WEST SUSSEX COUNTY COUNCIL CONSULTATION

TO:	Arun District Council FAO: Simon Davis
FROM:	WSCC - Highways Authority
DATE:	23 December 2019
LOCATION:	Land east of Shripney Road & south of Haddan House, Shripney Road, Bersted, PO22 9NW
SUBJECT:	BE/109/19/OUT Outline application with some matters reserved for up to 46 No dwellings together with access. This application is a Departure from the Development Plan. More information received.
RECOMMENDATION:	More Information
S106 CONTRIBUTION TOTAL:	provided separately

PROJECT: SHRIPNEY ROAD, SHRIPNEY		
CLIENT: HANBURY		
PROJECT REFERENCE: 1845	DRAWING NUMBER: 07	SCALE: 1:1,000 @ A3
SHEET NUMBER: SHEET 1 OF 2

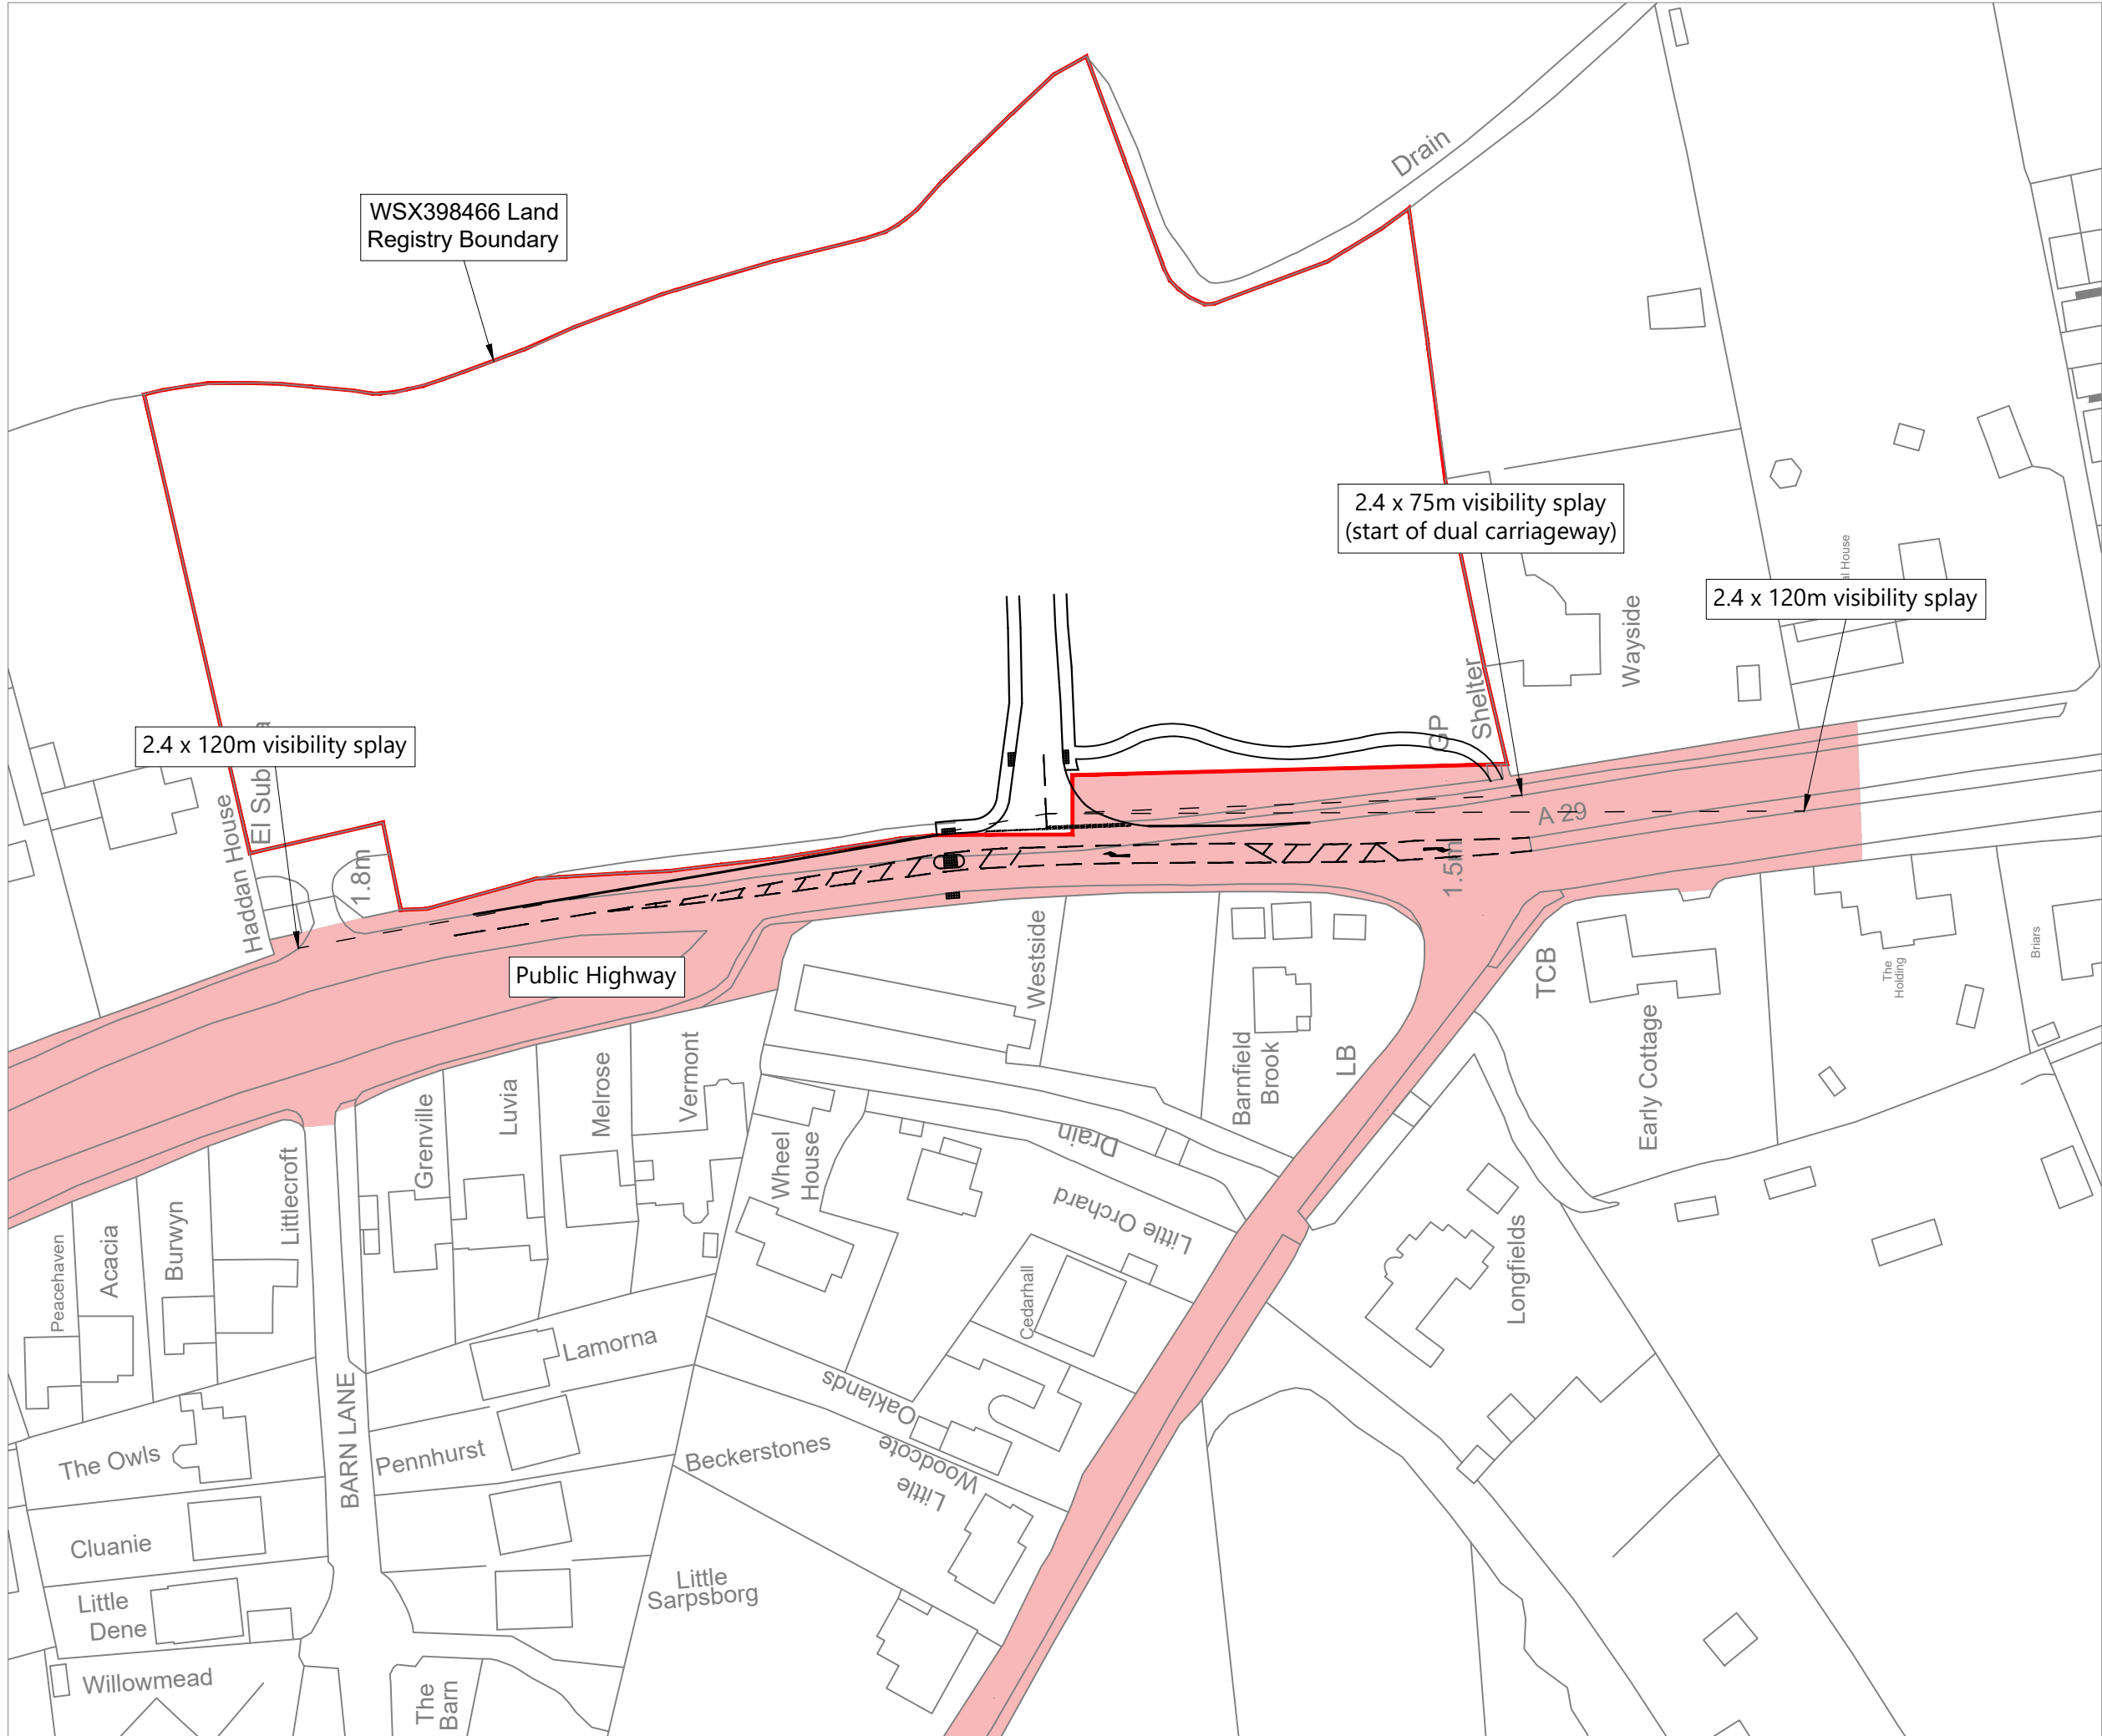
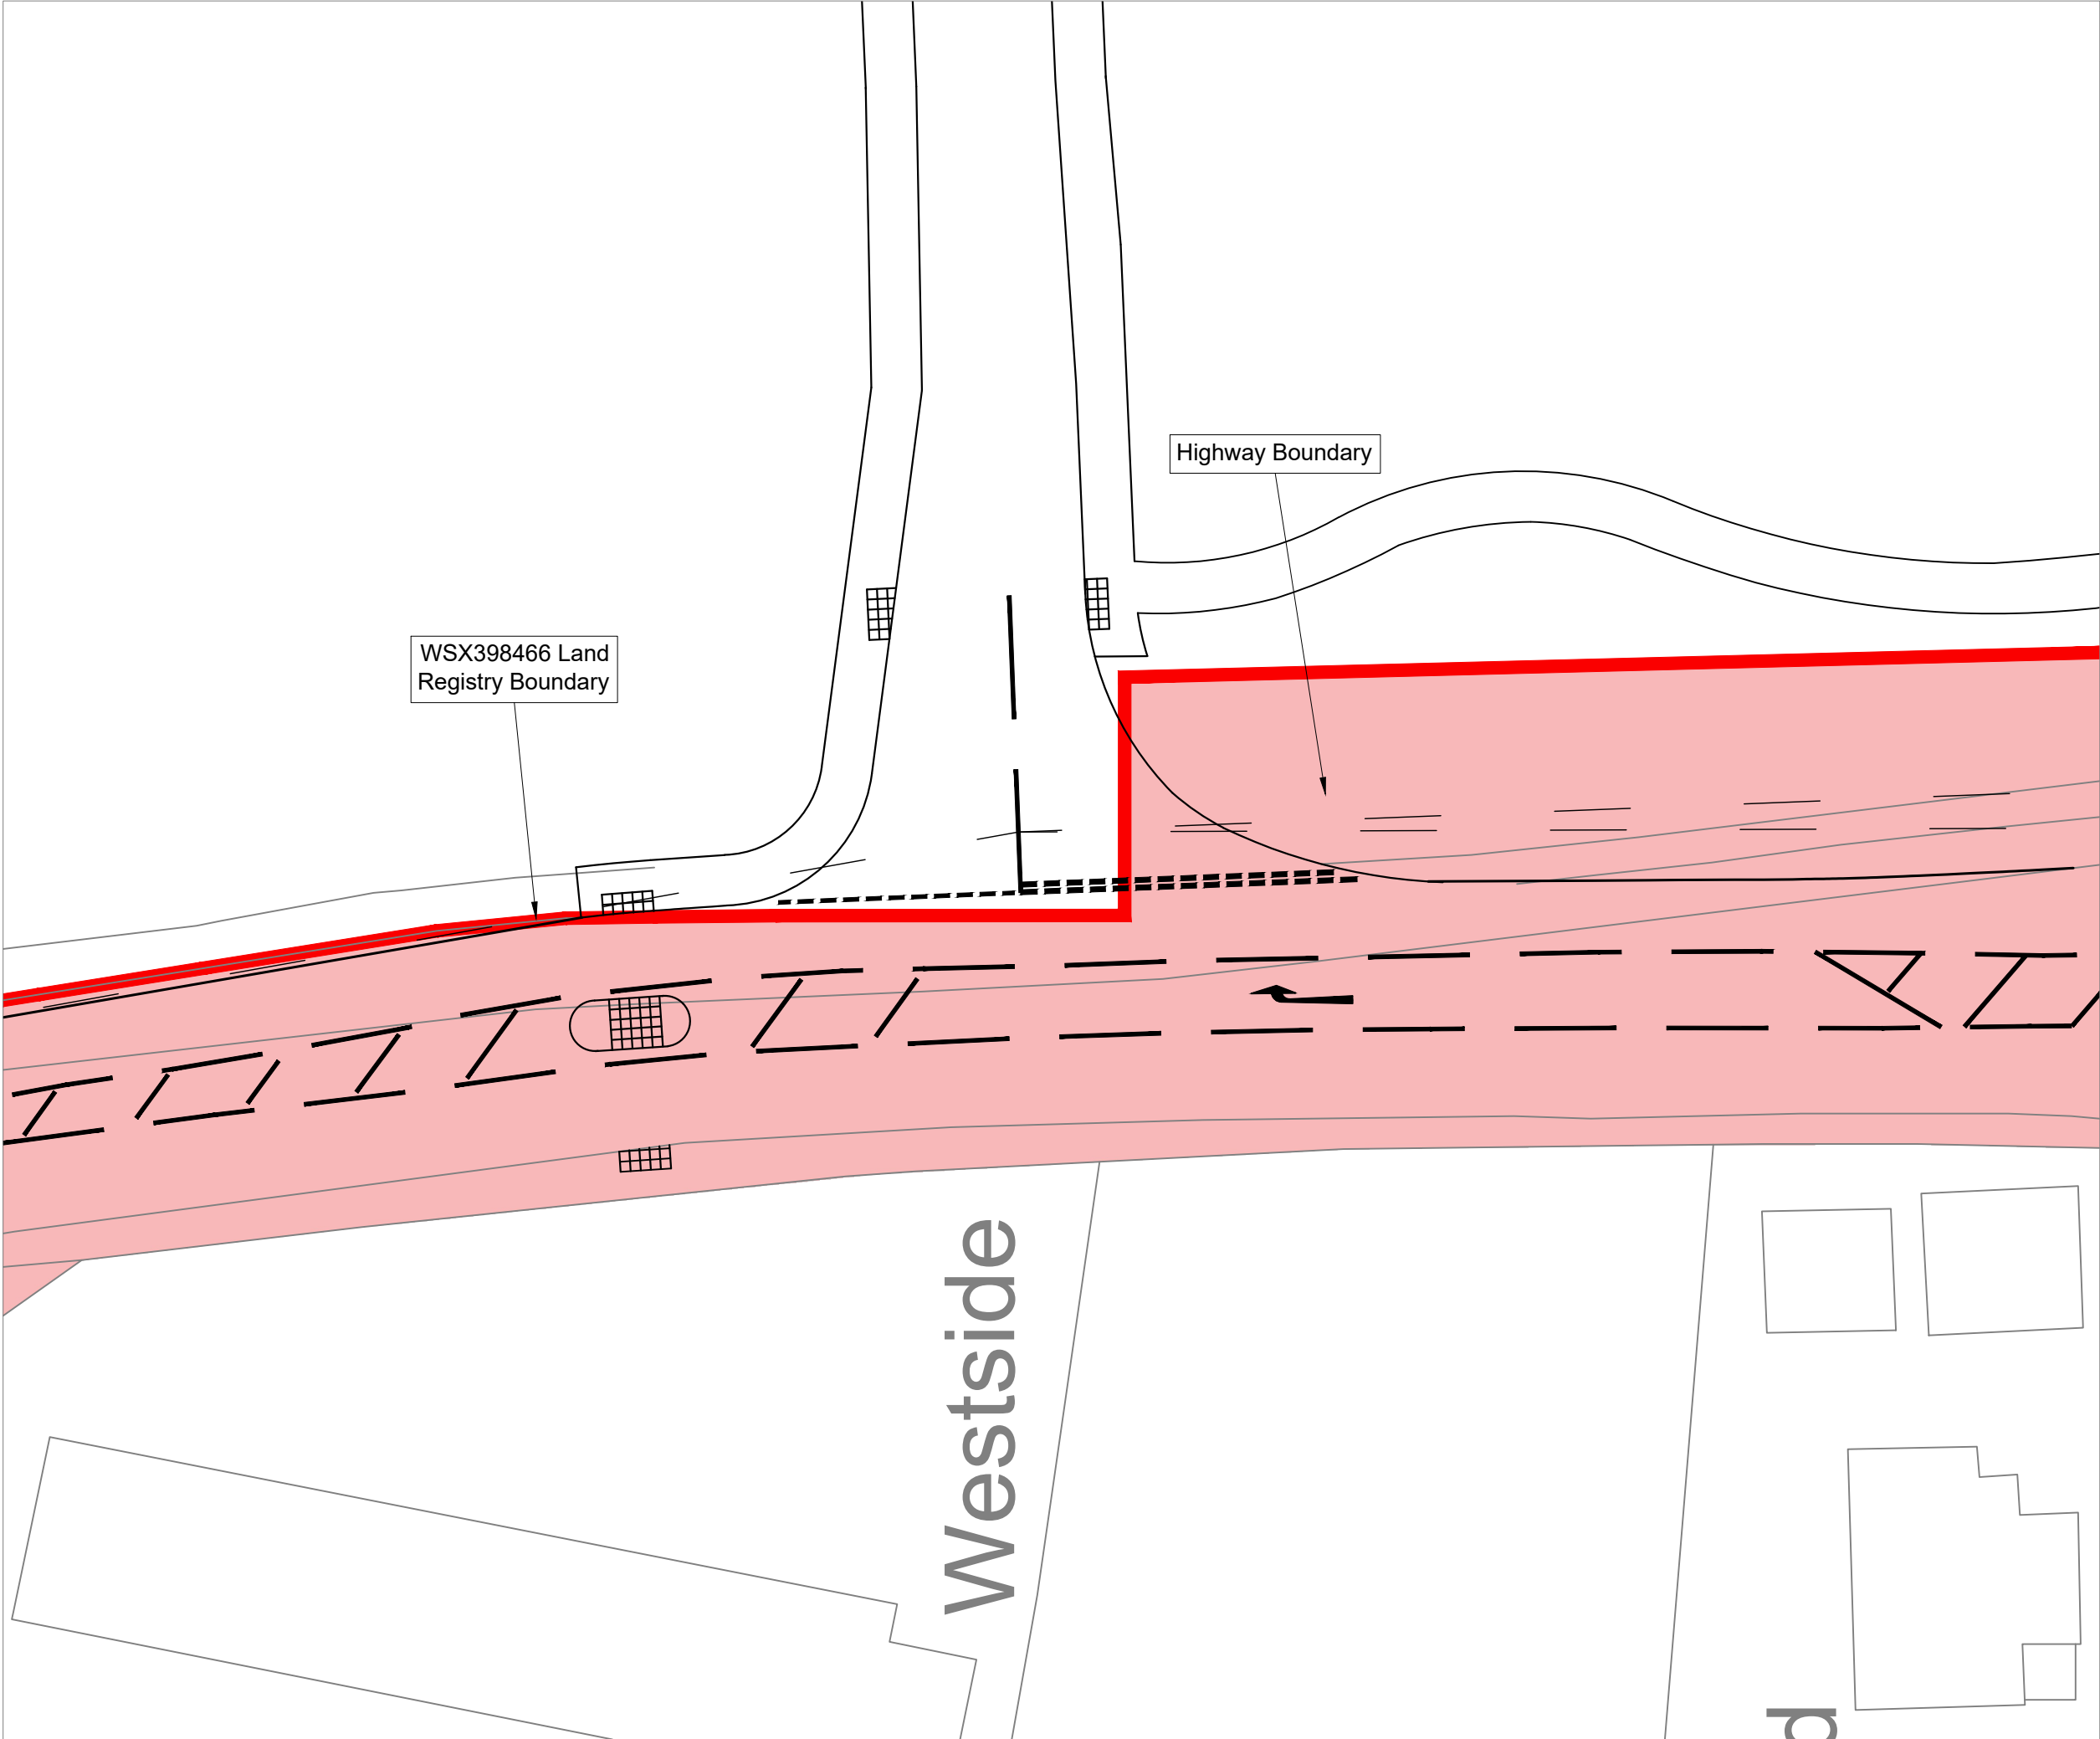
Auditor has raised that realignment of southbound carriageway will move road users closer to ditch on east side, increasing risk of vehicles ending up in ditch following loss of control collisions. Auditor recommends that a road restraint system is used to protect road users from falling in to ditch. The DR states that ditch will be culverted as part of access highway works - need for restraint systems will be discussed with LHA.

Auditor raises that road realignment will lead road users to drive closer to ditch and that pedestrians using new footway on east side of A29 may be at risk of falling in to ditch. Auditor recommends that appropriate protection for pedestrians is provided. DR states that double yellow line TRO (Traffic Regulation Order) will be considered at detailed design stage. The LHA is unclear as to how this will protect pedestrians from ditch and would expect DR to be similar to point 2.3, in that the ditch will be culverted.

The Transport Consultant states that an additional dropped kerb pedestrian crossing is proposed just after start of dual carriageway. The LHA raise concern with location of this across dual carriageway as pedestrians would effectively be required to cross two lane width at the point where vehicles may speed up to join dual carriageway. The crossing could be located just north of junction with Shripney Lane, within existing hatching. Relocation of proposed new crossing should also be reviewed by the safety auditor. Linking footway could also be provided along eastern carriageway edge to link with
